**SSI-33143123 - Dendrobium Mine Extension Project - Environmental Impact Statement (EIS)**

Thank you for the opportunity to comment on the EIS for the purpose of the subject State Significant Infrastructure (SSI) proposal (Project) lodged by Illawarra Coal Holdings Pty Ltd (Applicant).

TfNSW's key objective in making this submission is to ensure protection of the partially constructed rail corridor from Maldon to Dombarton (Rail Corridor). The partially constructed Rail Corridor includes railway embankments, earthworks and drainage culverts.

# Predicted profiles of vertical subsidence, tilt and curvature along the disused railway corridor due to mining in Areas 3B and 5

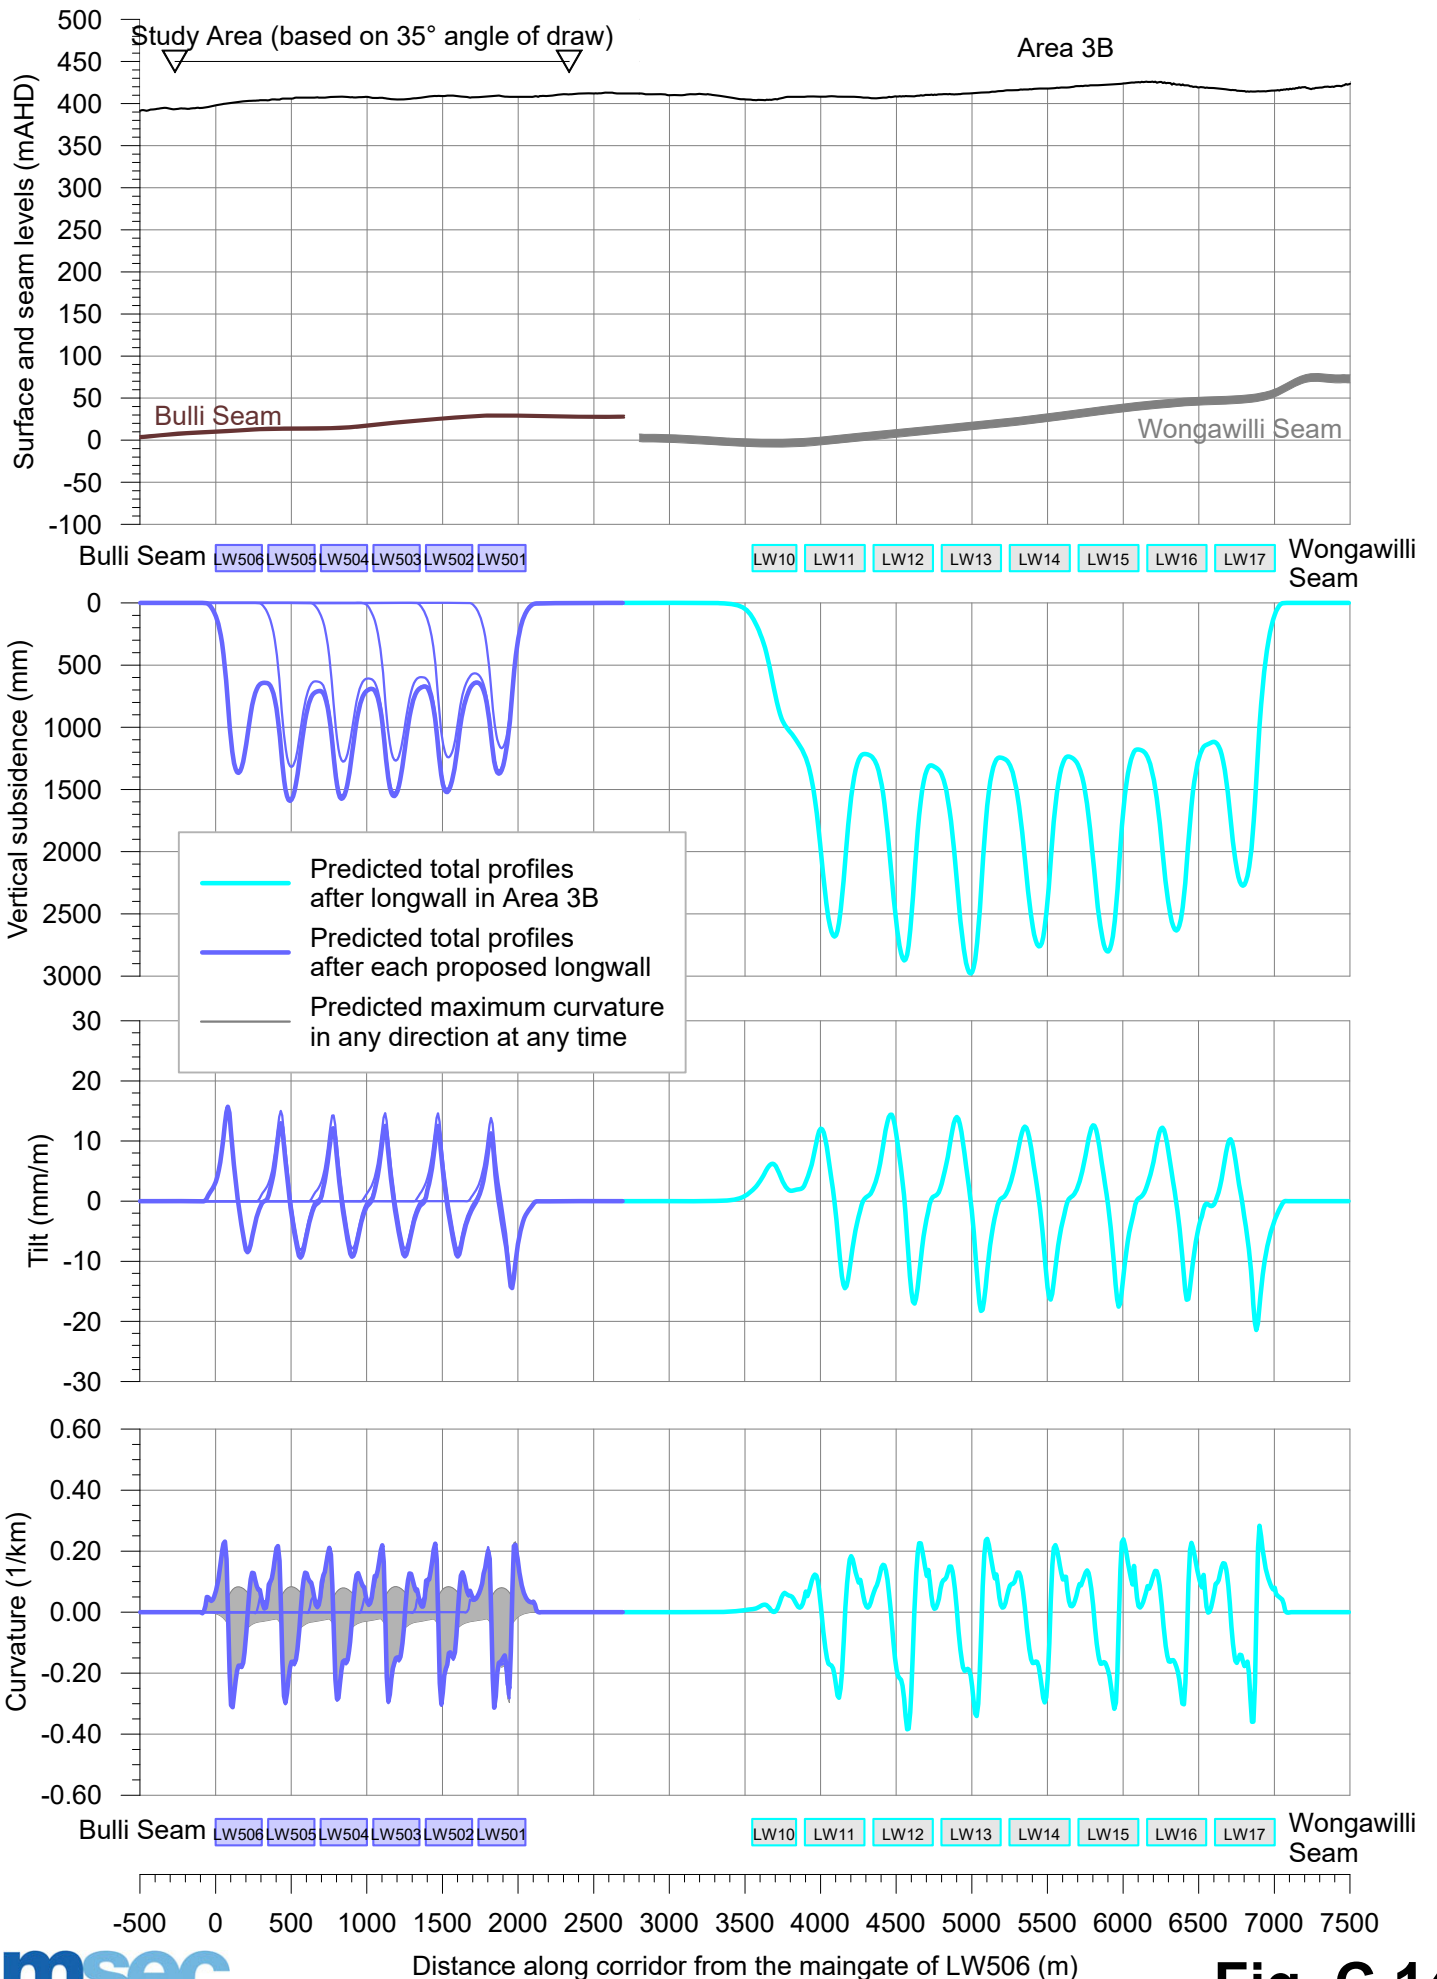
Appendix A of the Environmental Impact Statement predicts a maximum total vertical subsidence of 1600mm in the Rail Corridor and provides modelling details of other subsidence parameters such as tilt.

The Applicant should demonstrate that the ground movement (such as subsidence) of the railway formation due to the proposed longwall mining activities will not have an adverse effect on the partially constructed railway corridor. This should include ensuring that measures are in place so that TfNSW would incur no additional costs to complete the rail project.

TfNSW requires further justification from the Applicant that the proposed mining activities will not cause unacceptable subsidence of the railway formation and requires this to be provided in the response to submissions for consideration before the application for SSI approval is determined.
